# Colston Budd Rogers & Kafes Pty Ltd

20 July, 2022

**RE: STAGE 3 (DFO) EASTERN CREEK QUARTER**  
**UPDATED TRAFFIC MODELLING TECHNICAL NOTE -**  
**ROOTY HILL ROAD SOUTH – CHURCH STREET – ST AGNES AVENUE**

INTERSECTION LAYOUT - TURNING PATHS

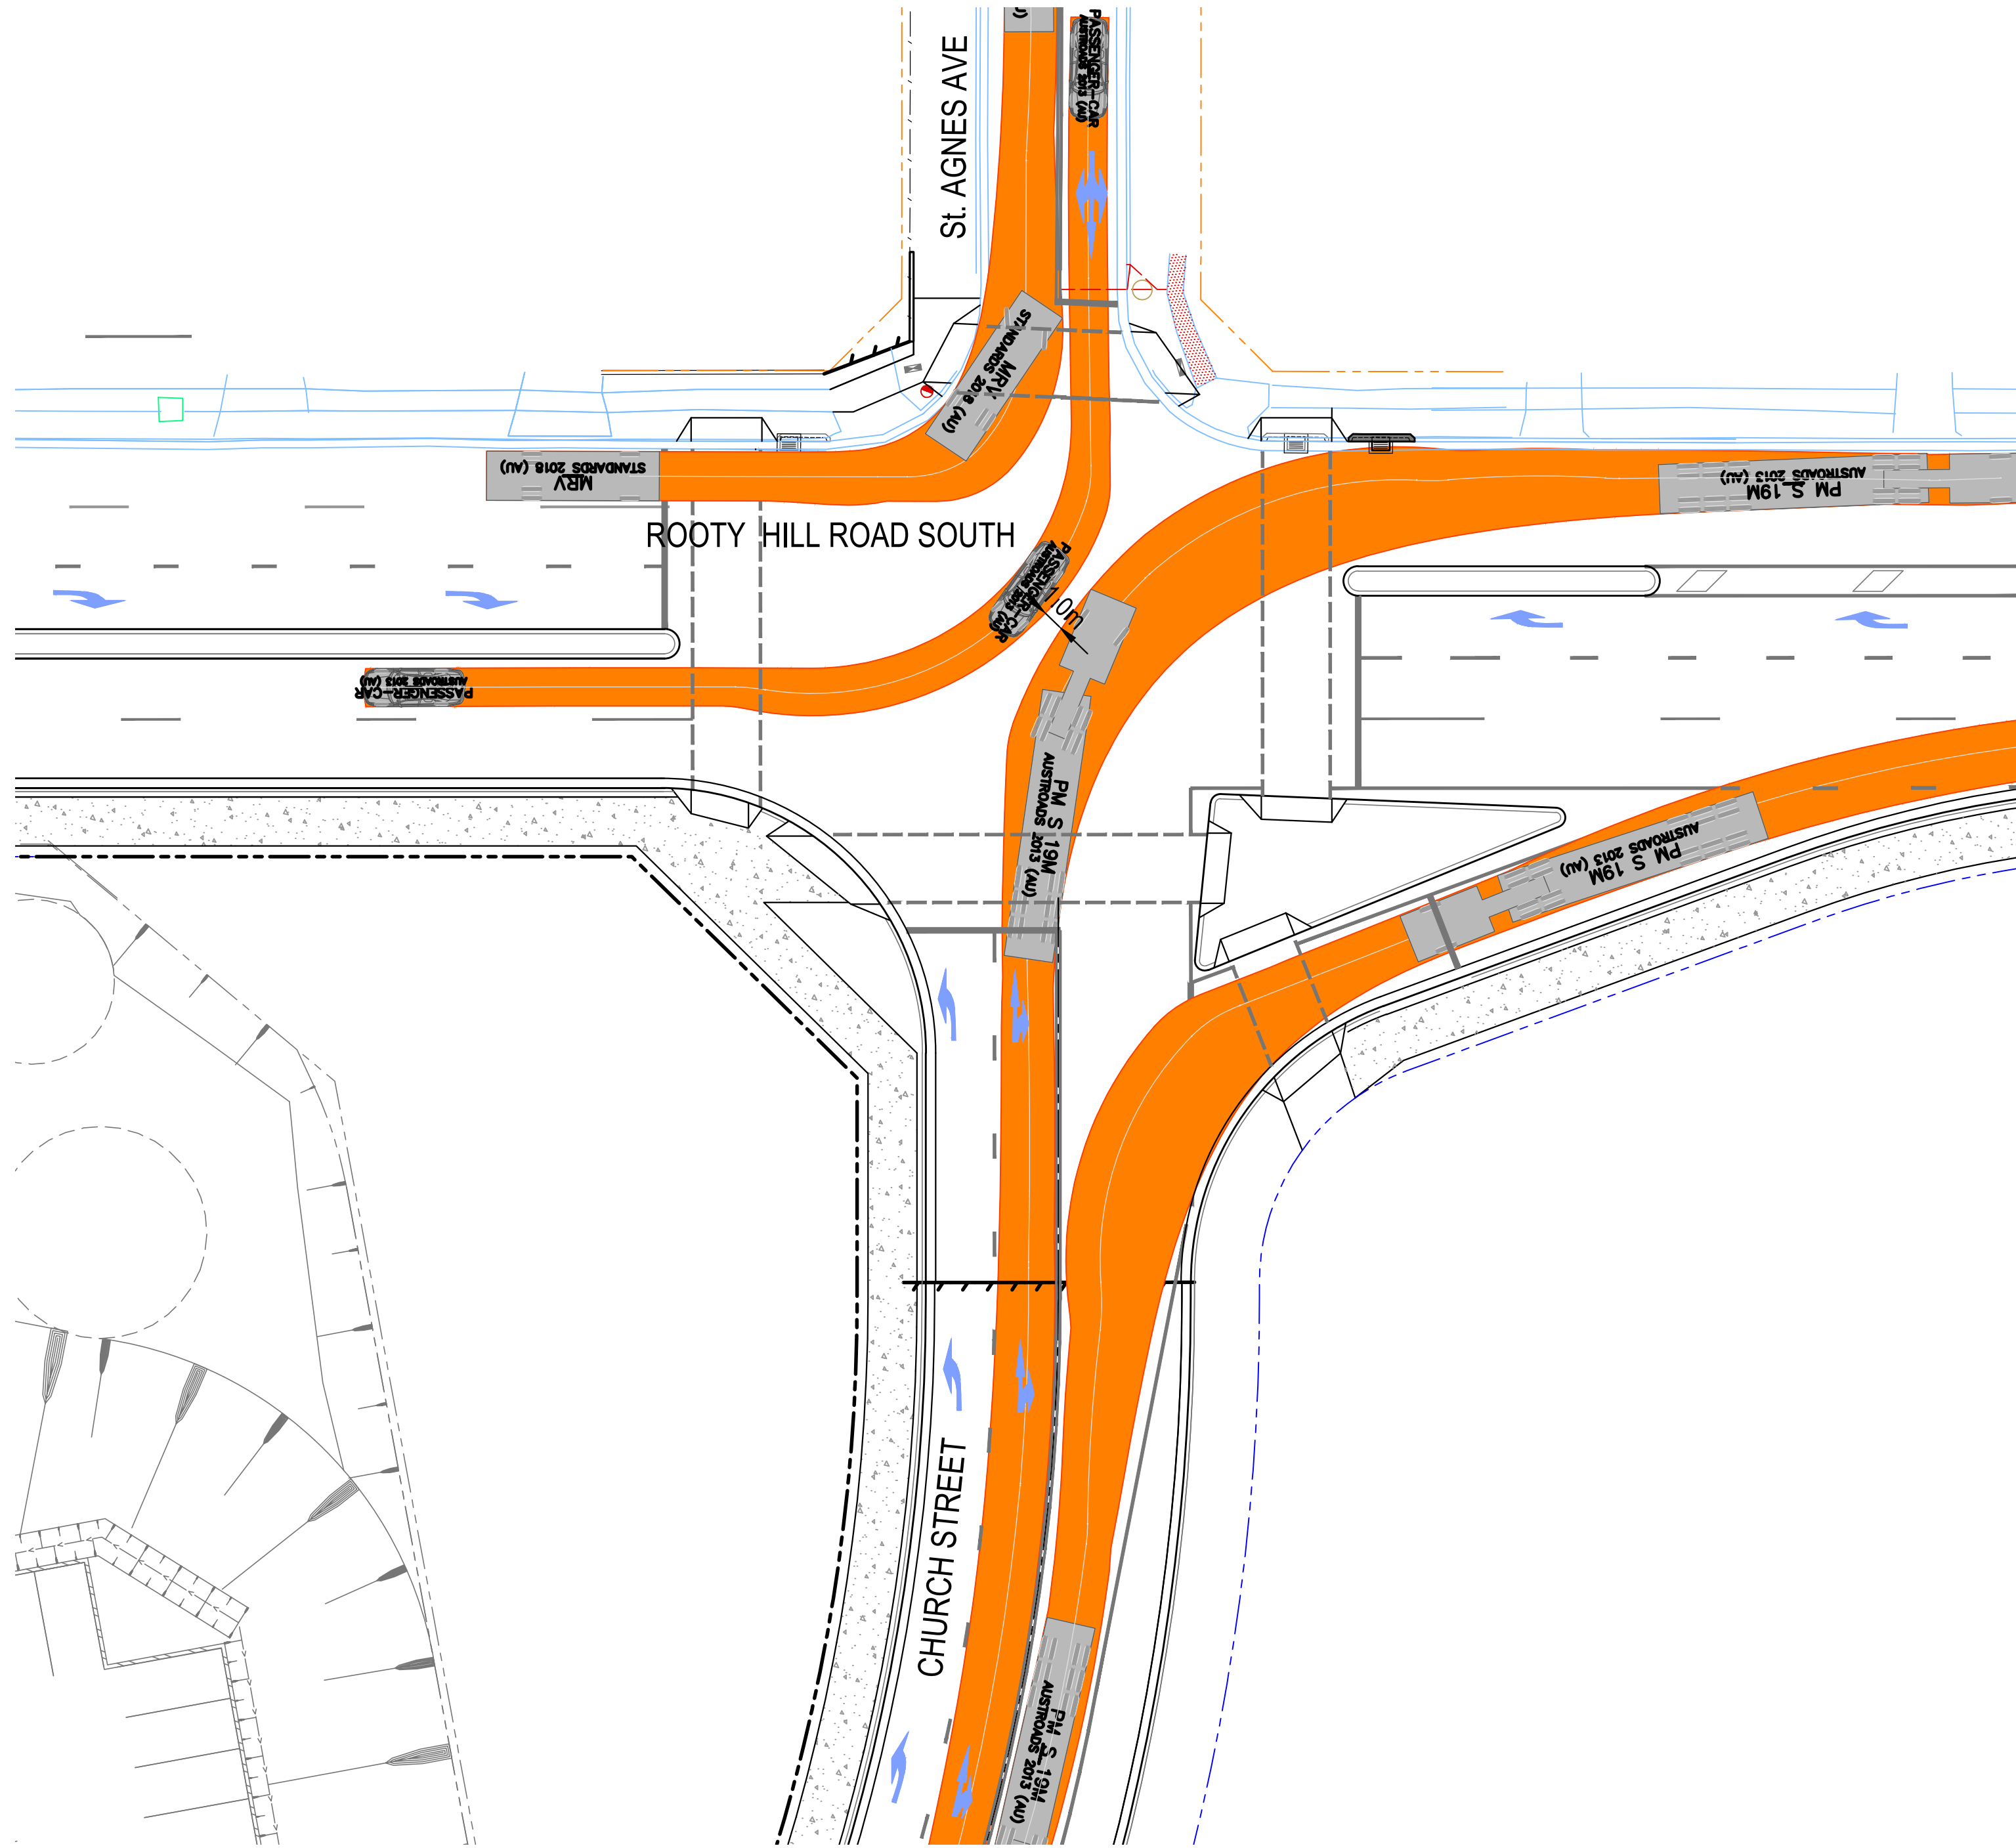
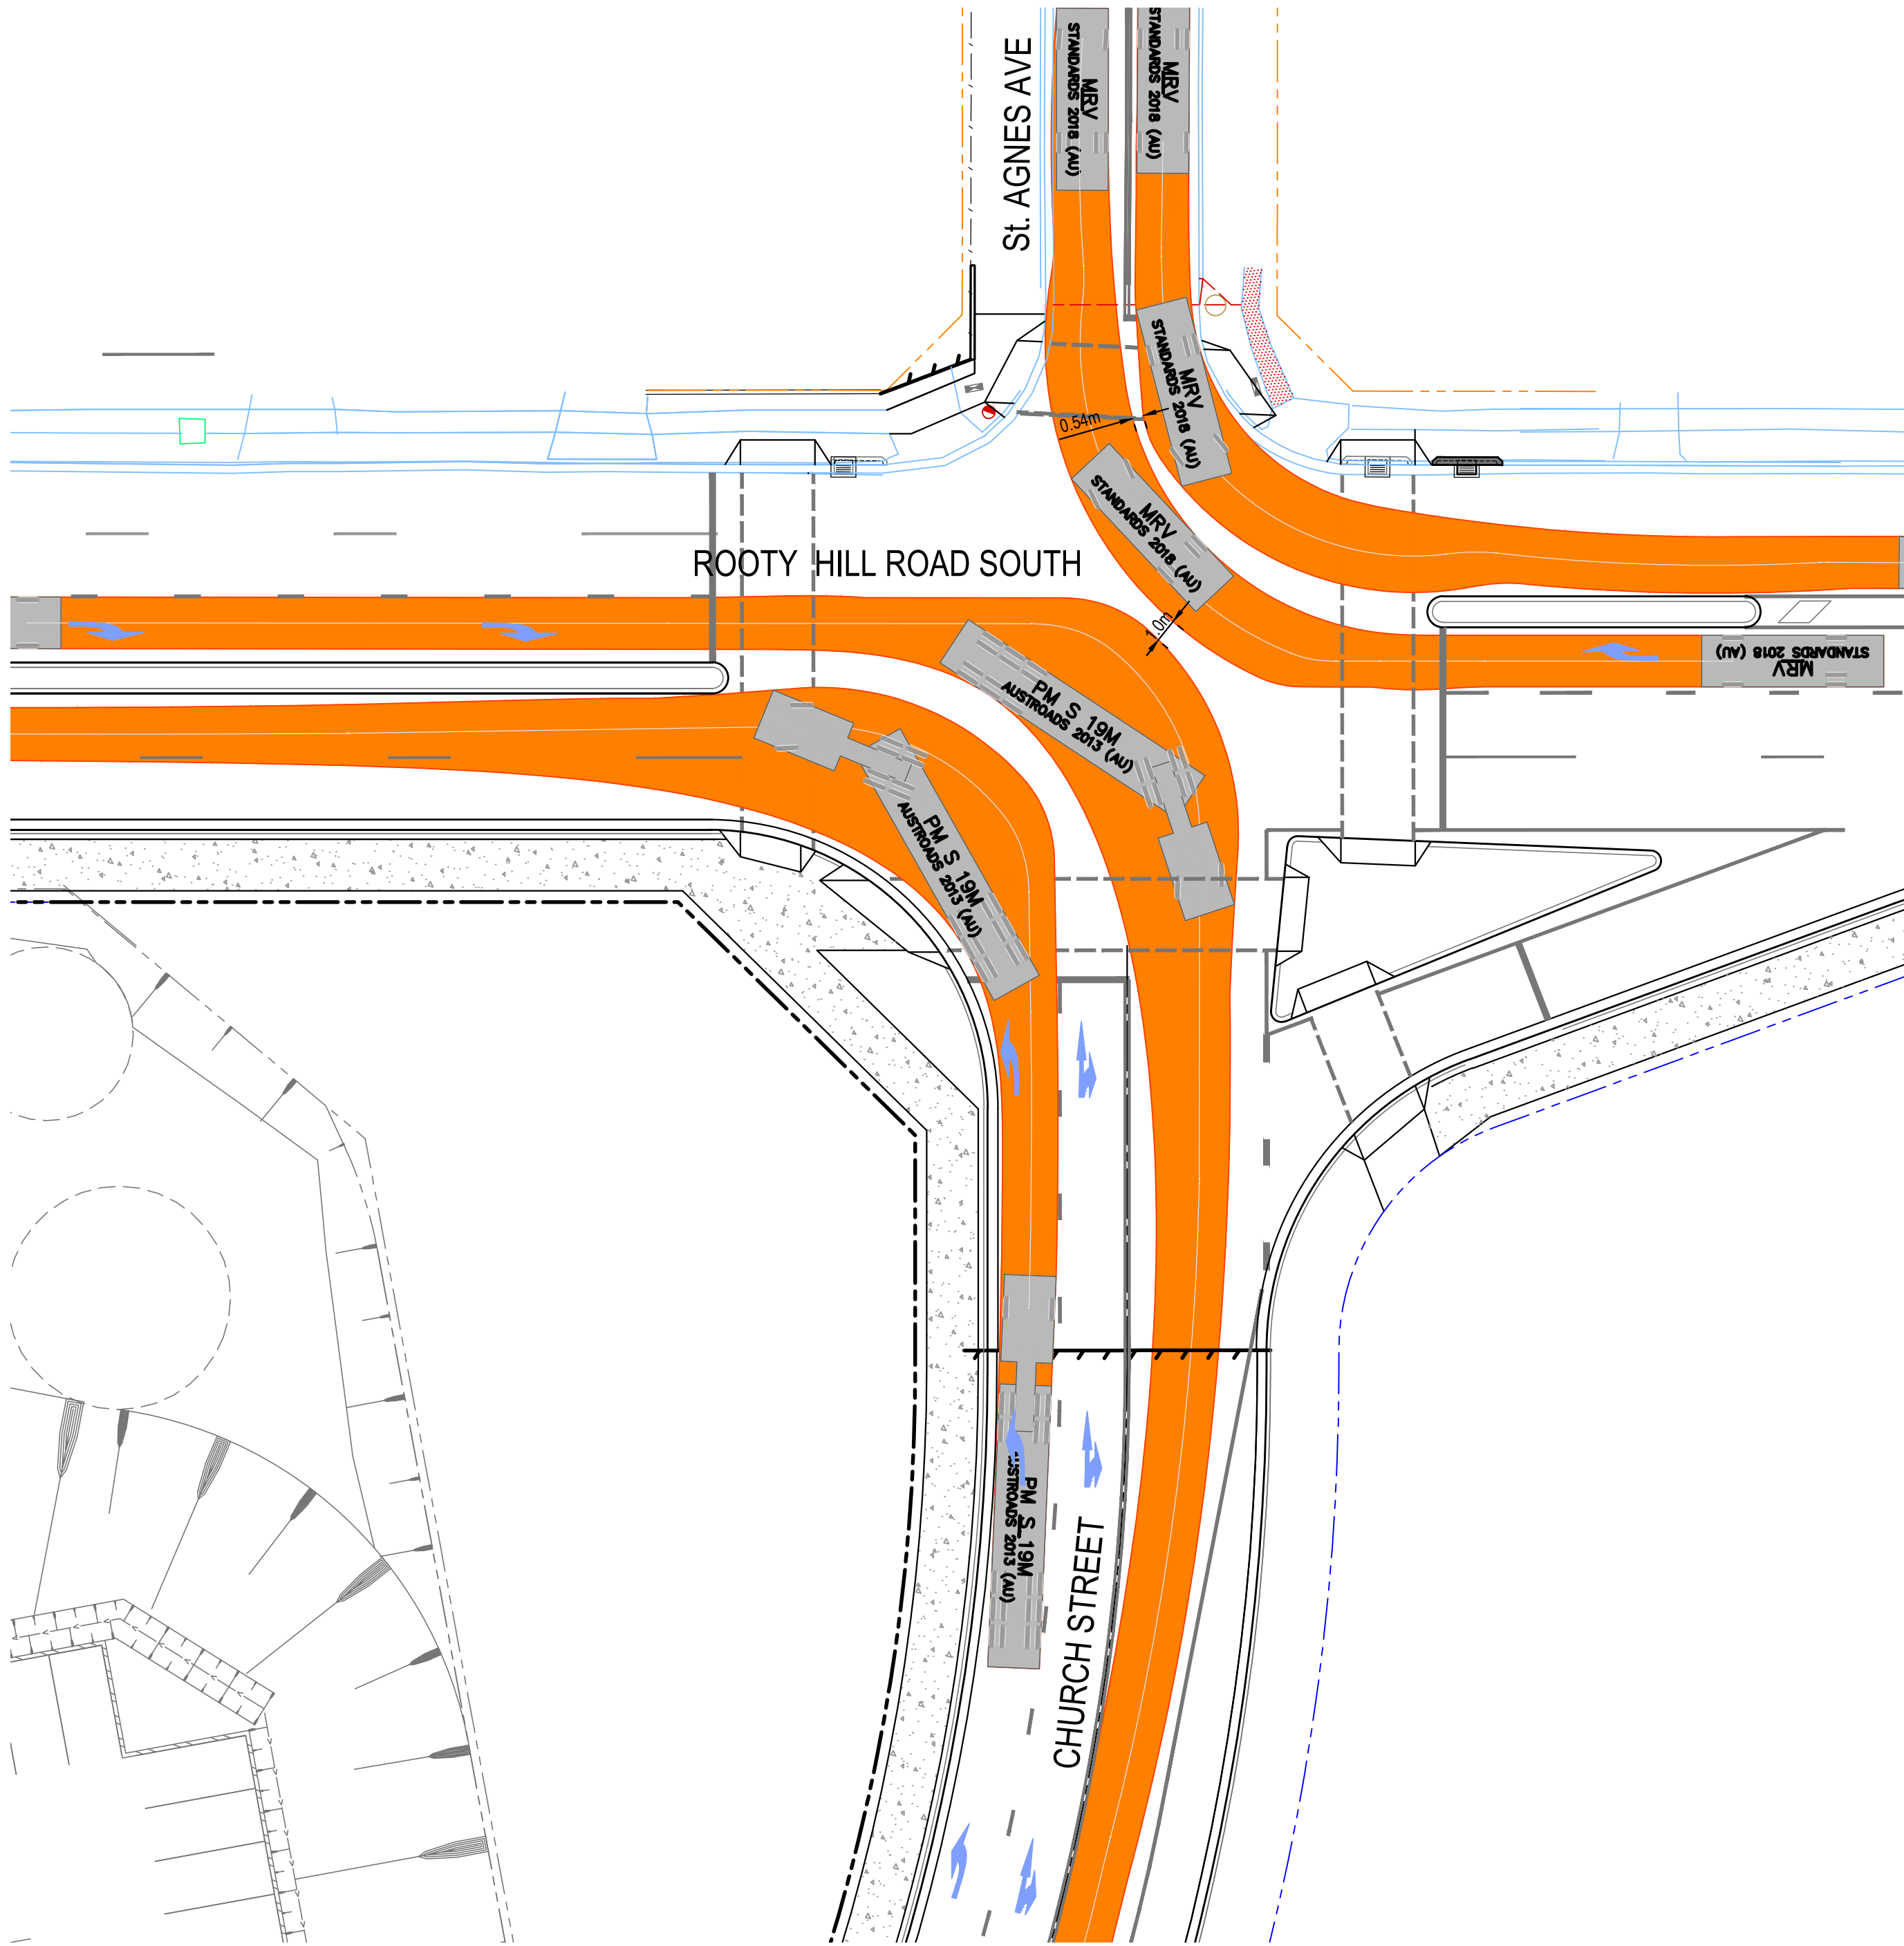
- *Rooty Hill Road South and Great Western Highway*
- 4) *The turn path for MRV turning left from Rooty Hill Road South into St Agnes Avenue encroaches on the kerb, please address this issue.*

SCALE: 1:500@A1

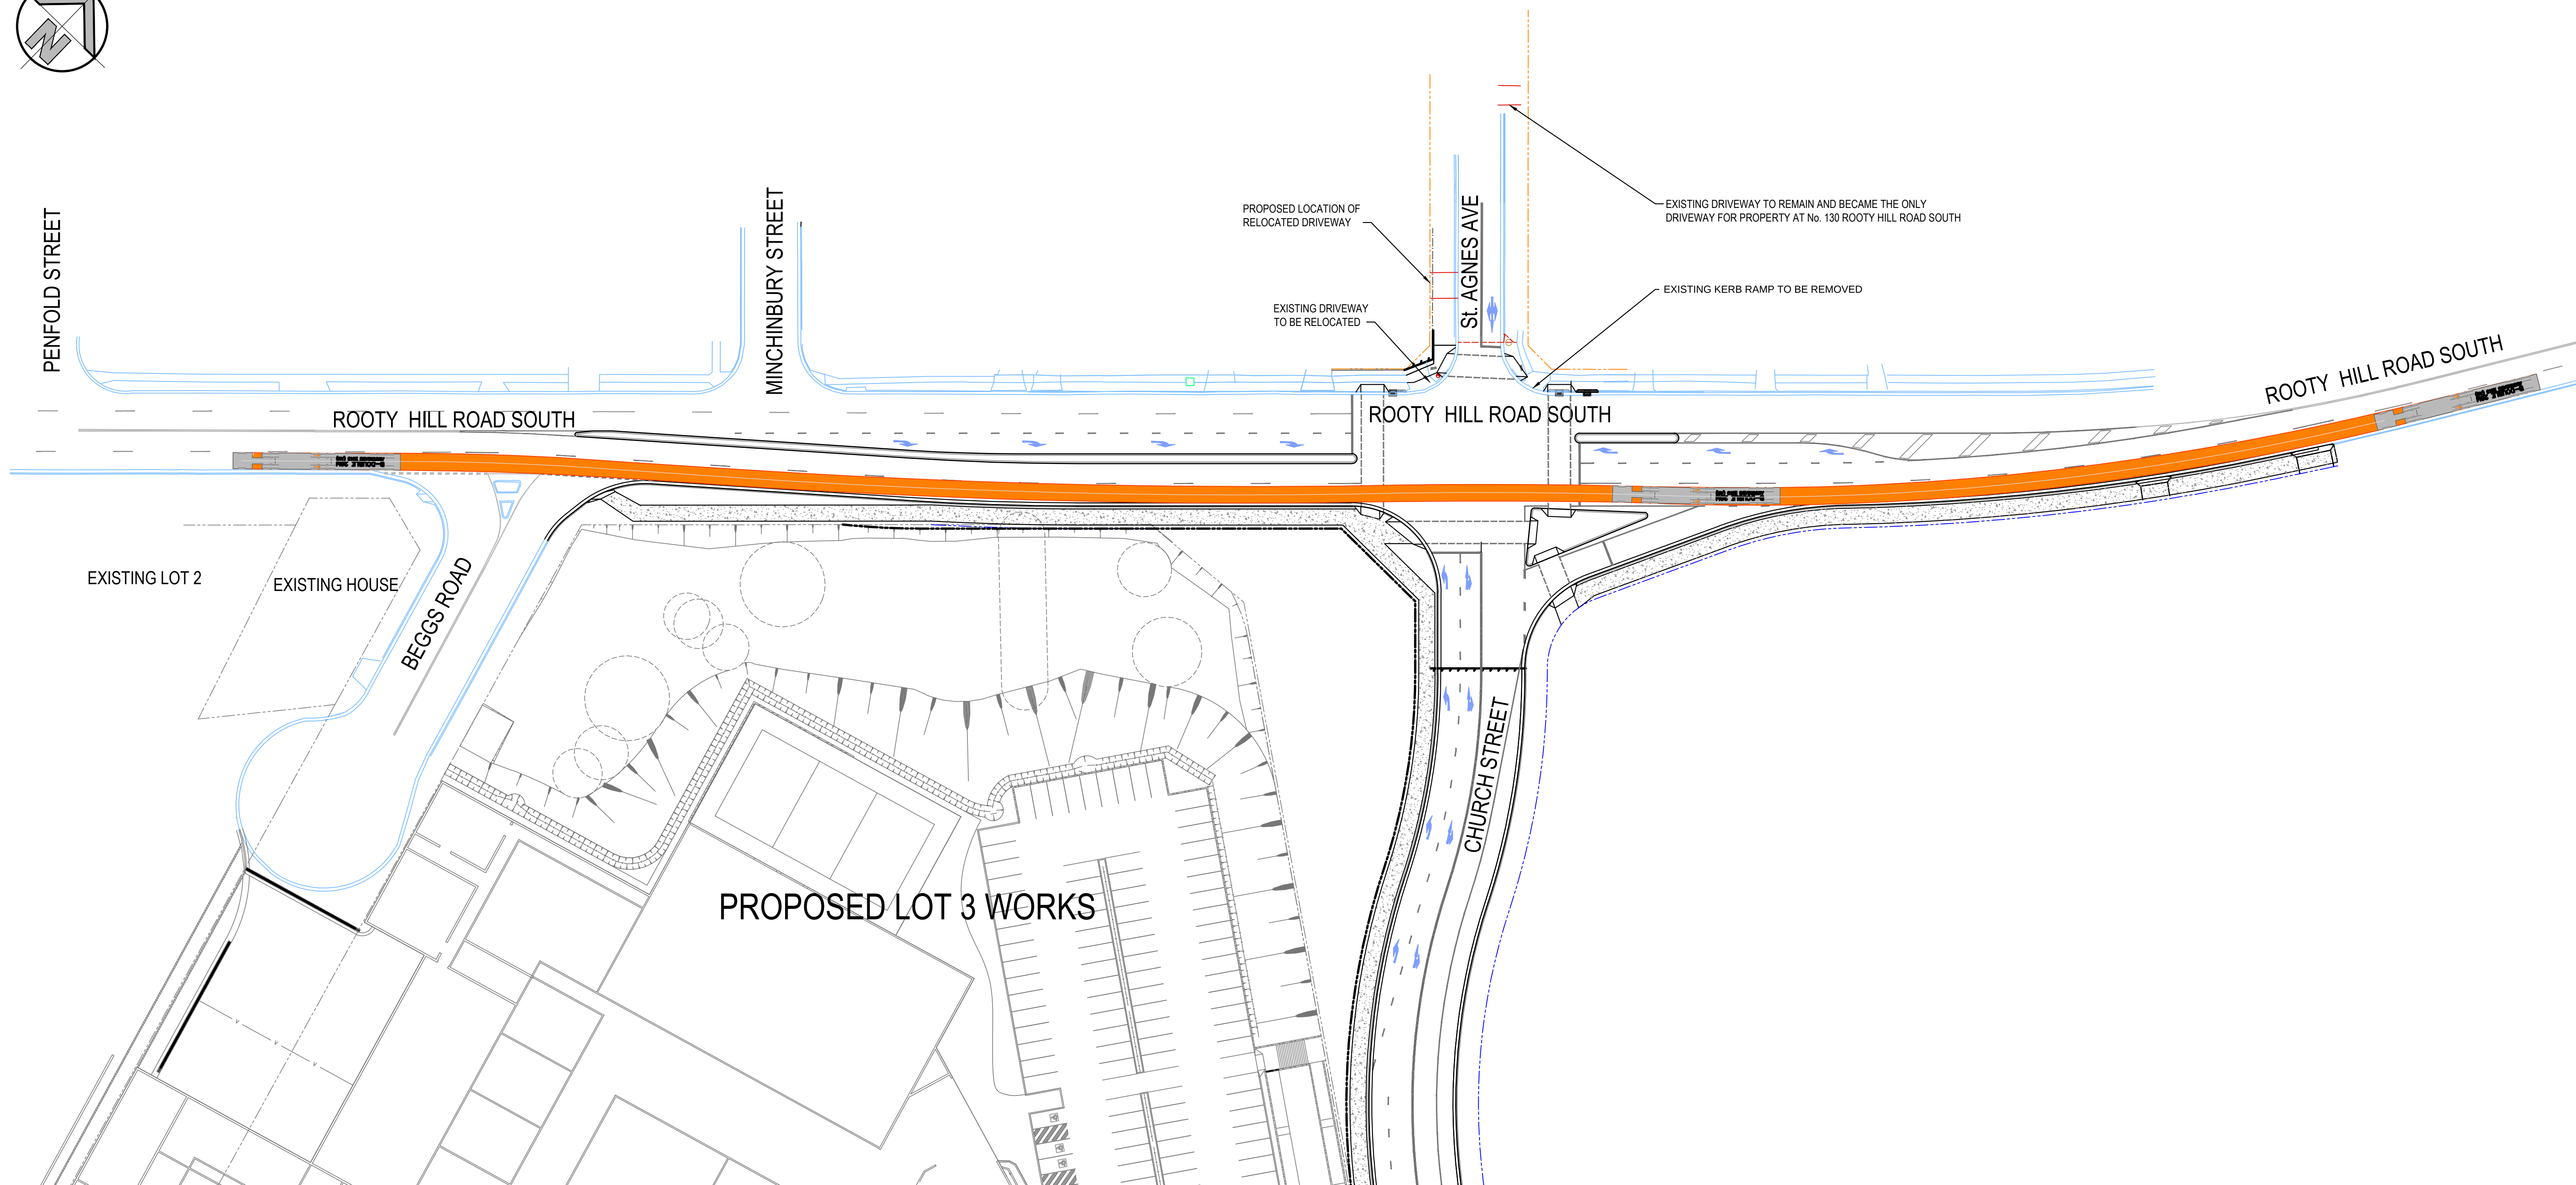
- 5) *TfNSW raises no objection to the Rooty Hill Road South realignment near Beggs Road with the suggested radius. At the 65m length from the stop line, the width of the right turn lane taper is 2.5m, which can only accommodate a car. It is recommended that the median width be reduced to 1.2m from Beggs Road and then transition through the taper to the 1.5m median width. This will allow the width in this area (65m from stopline) increased to 2.9m providing a better outcome.*
